Consultation Response from KC,
Lead Local Flood Authority

2026/90108 Land off, Blackmoorfoot Road and Felks Stile Road, Crosland Moor, Huddersfield, HD4 7AD

Discharge of details reserved by condition 8 (temporary drainage) on previous permission 2024/92235 for reserved matters application (including consideration of appearance, scale, layout, access (including pedestrian and cycle access into and within the site and vehicular access within the site)) and landscaping) for the erection of 231 residential dwellings and associated works including landscaping and the provision of open space pursuant to [WESTERN PARCEL of] permission 2024/92614 for variation and removal of conditions 4 (access works), 8 (Blackmoorfoot Road improvements), 10 (junction details), 16 (retaining wall design), 17 (highway structure design), 18 (surface water drainage strategy), 37 (external lighting strategy), 39 (crime mitigation measures) on previous outline permission 2020/92546 (with details of points of access only) for development of up to 770 residential dwellings (Class C3), including up to 70 care apartments (Classes C2/C3) with doctors surgery of up to 350 sqm (Class D1); up to 500 sqm of Class A1/

Client		MILLER HOMES	
Drawing Status	PLANNING	Date	MAY 2026
Scale	1:500	Drawn by	WC
Project	HAWKSLEY PARK BLACKMOORFOOT ROAD HUDDERSFIELD	Check by	TB
Drawing Number	6910-WTWD-00-XX-DR-D-9402	Revision	P2
Drawing Title	POLLUTION PREVENTION PLAN PHASE 2

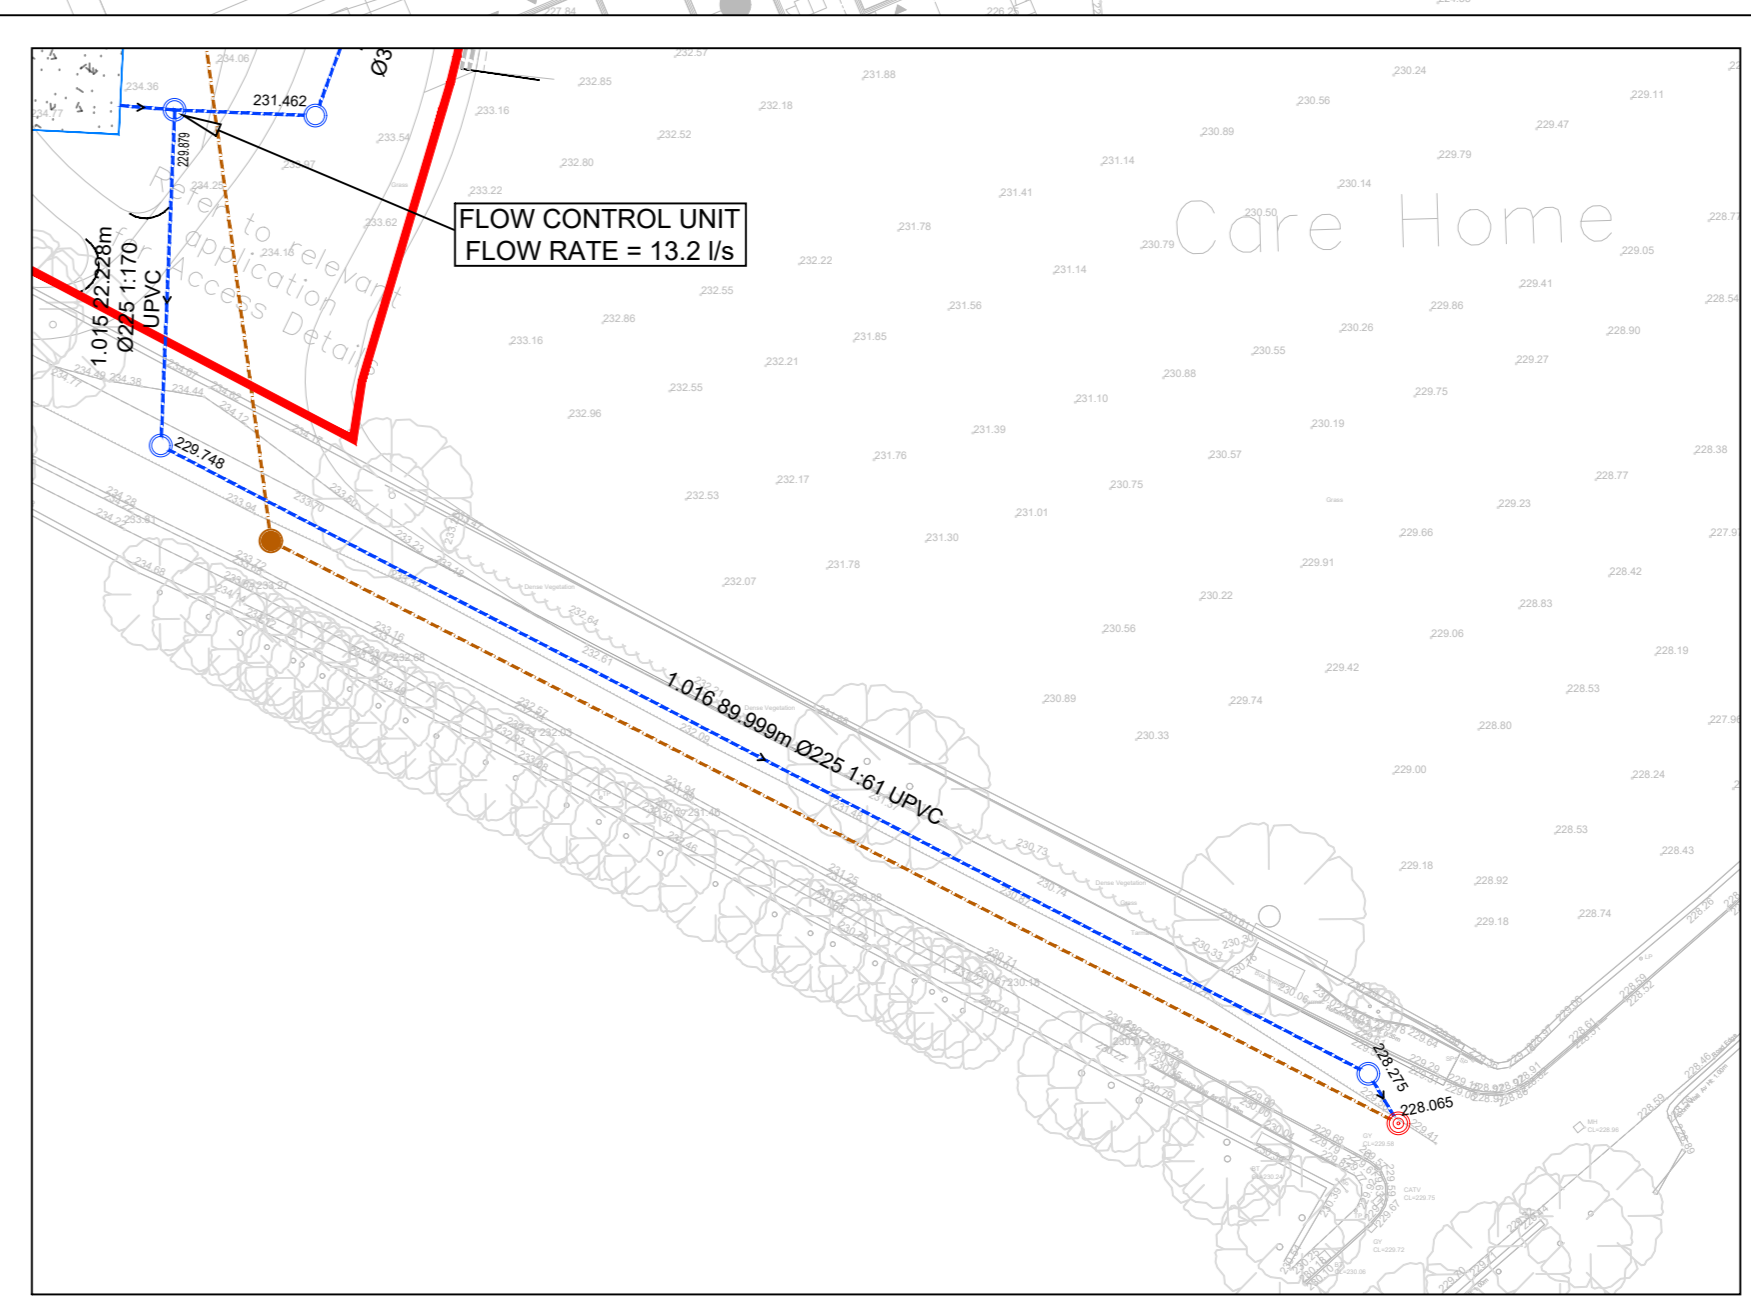
Although plans have advanced and now form two phases, before and after the attenuation tank is installed, a narrative has not been submitted. Please refer to our previous comments about linking this to a construction management plan (build programme, site strip minimisation, spoil location and run off flood route, gully and manhole protection, settlement of sediment, wheel washing, road sweeping etc.)

We recommend for performing a flood risk assessment that the method statement listed creating a schedule and itinerary of tasks and checklists, that back up plans to manage risk are stated here. For example, the use of the tanker to empty the storage, or flocculation is sedimentation was bad.
